**Notice of Exhibition
Marsden Park Warehousing and Light Industrial Estate (SSD 8606)**

Thank you for your letter dated 16 January 2018 requesting Transport for NSW (TfNSW) to provide comment on the State Significant Development (SSD) Application for the Marsden Park Warehousing and Light Industrial Estate, located at Lot 23 and Lot 24 DP 262886 Hollinsworth Road, Marsden Park.

CD18/00402

Figure 2: Proposed Site Layout

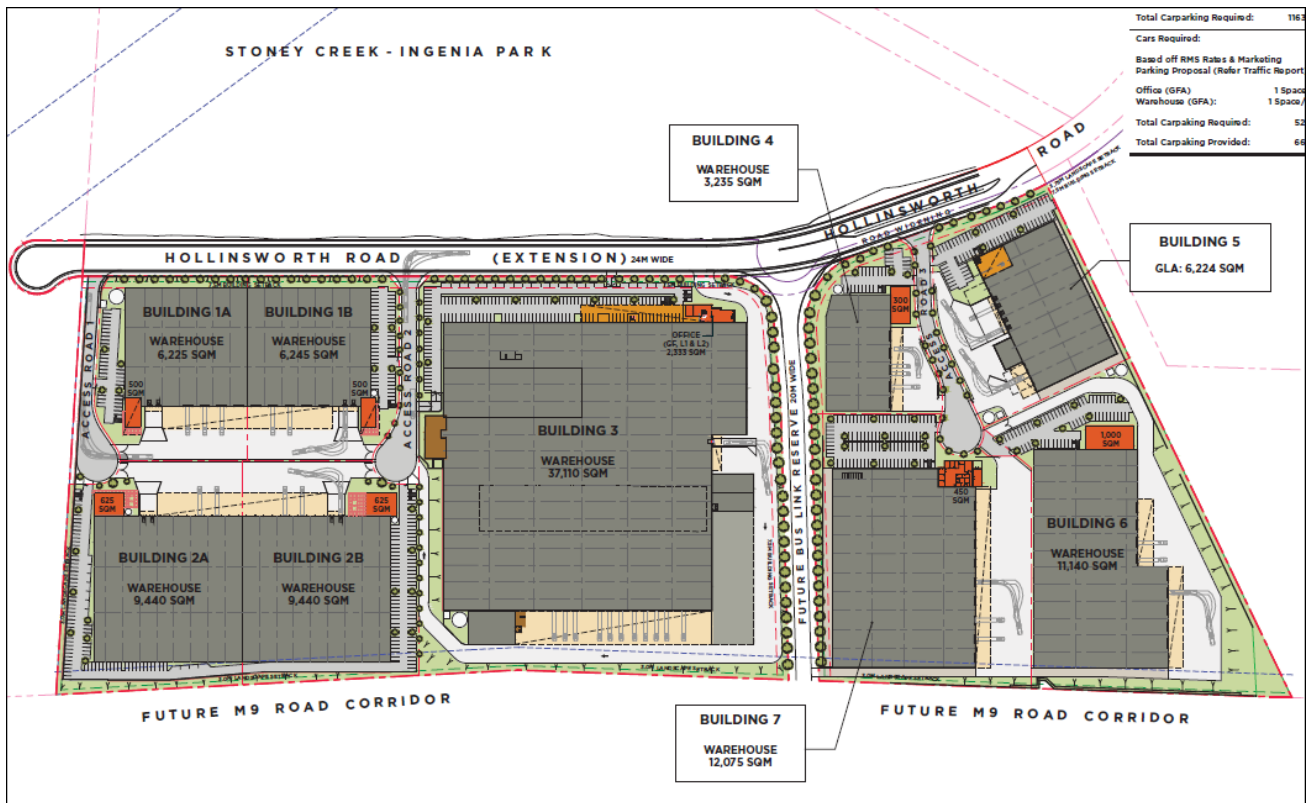
Based on a review of the abovementioned map, localised widening has been identified (extract provided in Attachment C). However, it is unclear whether the development design drawings (refer to Civil Drawings by Costin Roe Consulting and Architectural Drawings by Watch This Space Design) have considered the required spatial provisions of the future bus link, consistent with the relevant SEPP maps and the comments provided by TfNSW in relation to the subdivision DA.

- The EIS should assess the impact of the proposed development on the relevant land reservation acquisition maps and spatial provisions for a future bus link.
- DP&E should ensure that all proposed buildings and structures integral to the operation of the respective developments is clear of the reservation for a future bus link.
